Application No: FG/6/26/PL

Site Address: Little Twittens Recreation Ground Sea Lane Ferring BN12 5DY

Description of works: Installation of a new double non turf cricket training strip (astro wicket) within the existing playing field, replacing astro surface with a new ECB approved synthetic surface, reorientation from east-west to south-north for improved safety and usability, new wicket will be installed on a dynamic aggregate base using the Notts Sport Envelope System with a NottsGrass Ultra surface, the strip will be slightly extended to ensure bowlers land on the synthetic surface rather than grass, preventing damage to the outfield and improving safety of players and walkers using the field alike. This application is in CIL Zone 4 (Zero Rated) as other development.

Pre development
Plan
Baseline Map

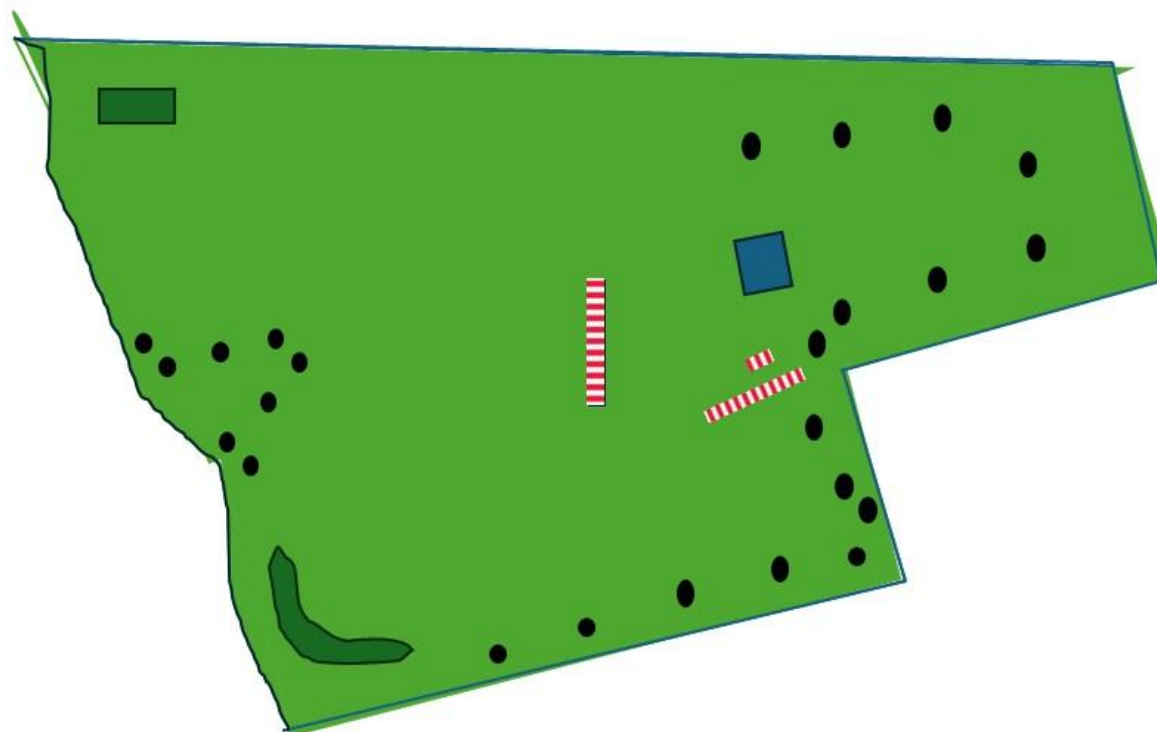
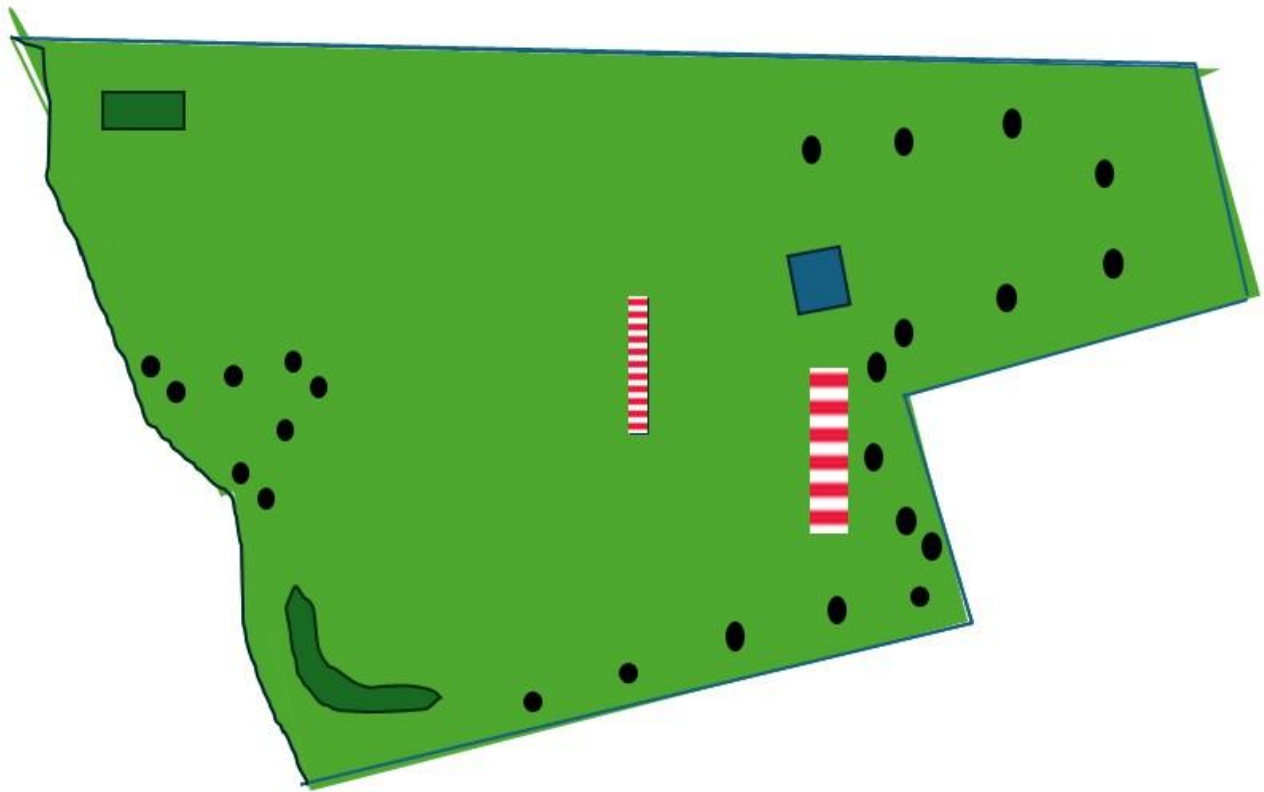
1. Bats and their roosts are fully protected by law in the UK due to their declining populations. Activities that may disturb bats need to be given careful consideration and a wildlife assessment must be completed.
2. The application states that 'The proposed site is shielded by trees on the housing side and these would be unimpacted with no excavation or works will take place within root protection areas, and has left a gap to the south to allow continued access even when the astro is being used'. Within the plans, the proposal is shown right up to the tree line with very little gap.
3. Arun District Council has requested an illustration for a 70 square metre flowerbed; however, this illustration does not appear to be available on the portal.
